Application number: 2023/90775	
What is the application for?:	Erection of single storey front and side extension and formation of vehicular ac
Address of the site or building:	50, Birkby Lodge Road, Birkby, Huddersfield, HD2 2BG
Postcode:	HD2 2BG

Site Plan 1.500

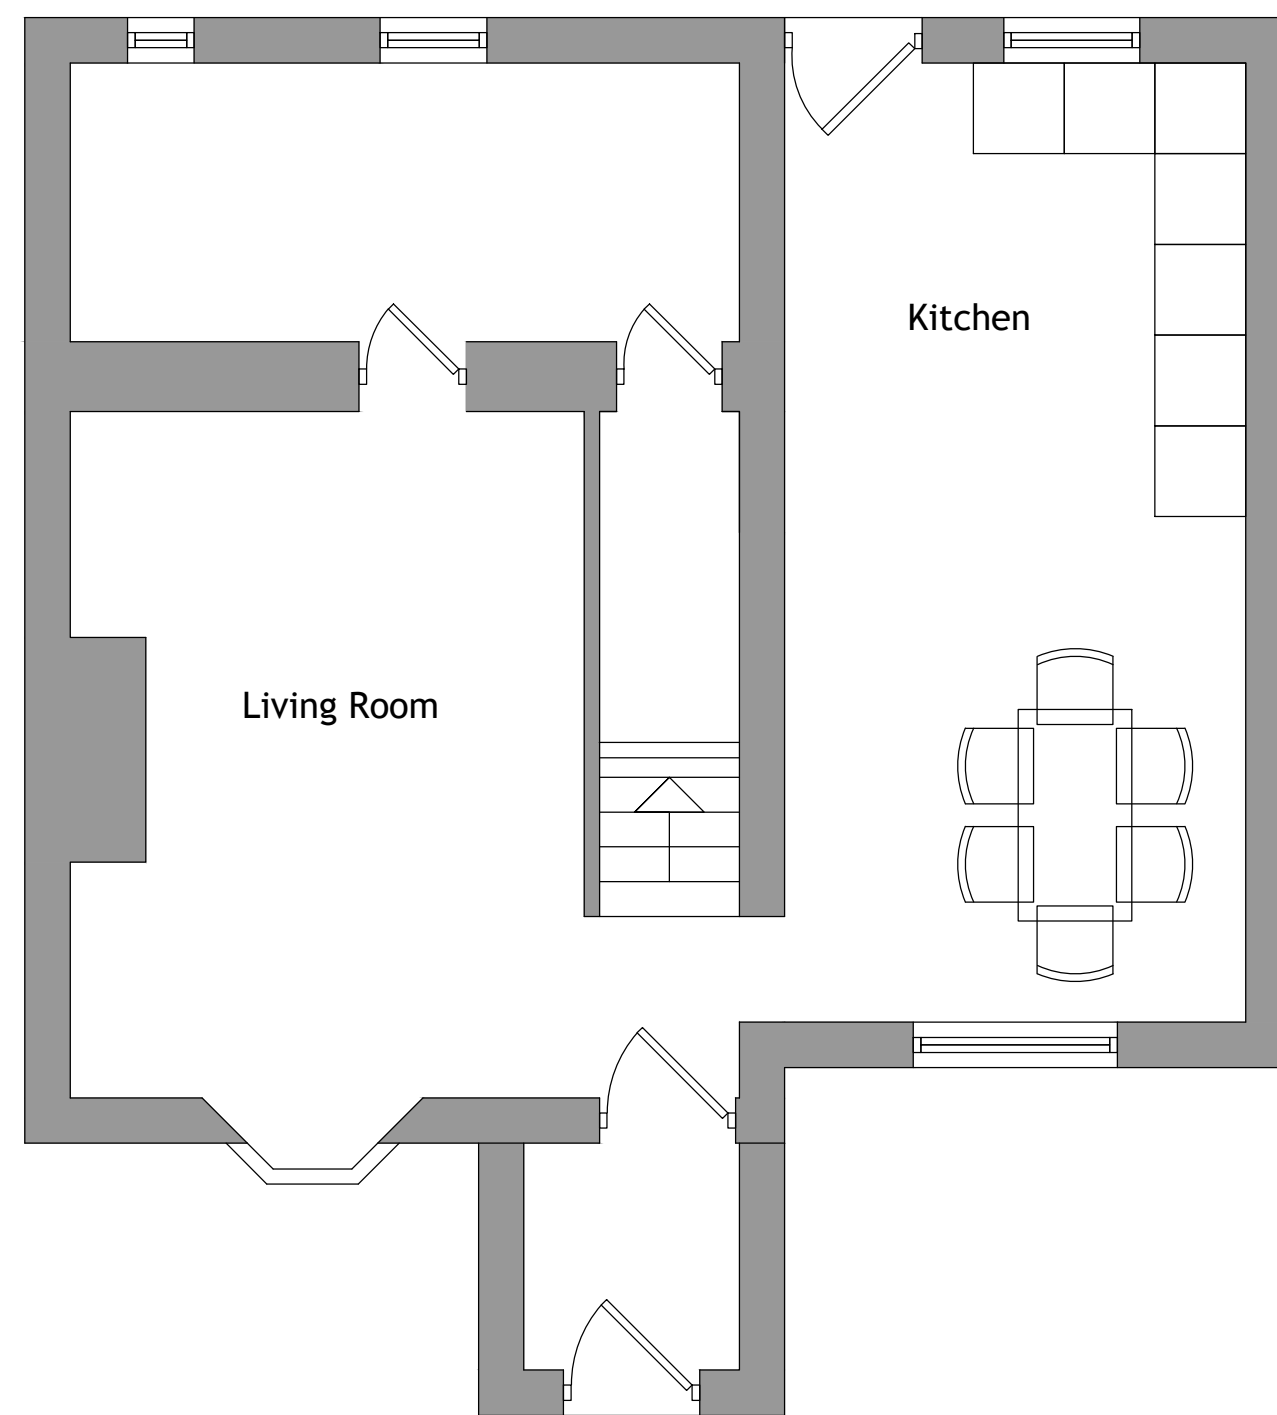
Type of comment: An objection	
Do you wish your comments to be published on the website anonymously?	Yes
I object to the planned formation of vehicular access within this proposal. To do this would involve the removal of an old stone wall which is currently providing an invaluable habitat for the smaller creatures that form the bottom of the food chain. I believe it's destruction would have an adverse impact on these smaller insects and the wildlife that rely on them. Its loss would also affect the beautiful character and aesthetics of this area of Birkby which is well known for its lovely stone boundaries. The proposed vehicular access is currently a Right of Way that's been well used by locals for generations. It allows unrestricted pedestrian access from Birkby Lodge Road to the Birkby Community Wildlife Garden as well as Ponyfield Close, Old Hopkinson Drive and beyond. A driveway for vehicles would lead to serious health and safety risks for pedestrians, as well as restricting access to this well used RoW. The erection of a single story side extension would harm the visual appearance of this area. This would be keenly felt by those enjoying and working in the Birkby Community Wildlife Garden as well as those using the footpath. The white render currently on the building already draws the eye. This would become a genuine eye sore if a white rendered side extension was to be built. The supporting evidence clearly states that the front garden is grass and will remain as such. This statement is incorrect, there is no grass in the front garden as it has already been removed along with the majority of vegetation. Please take my comments on board. I love Birkby and would hate to see it's character destroyed bit by bit.
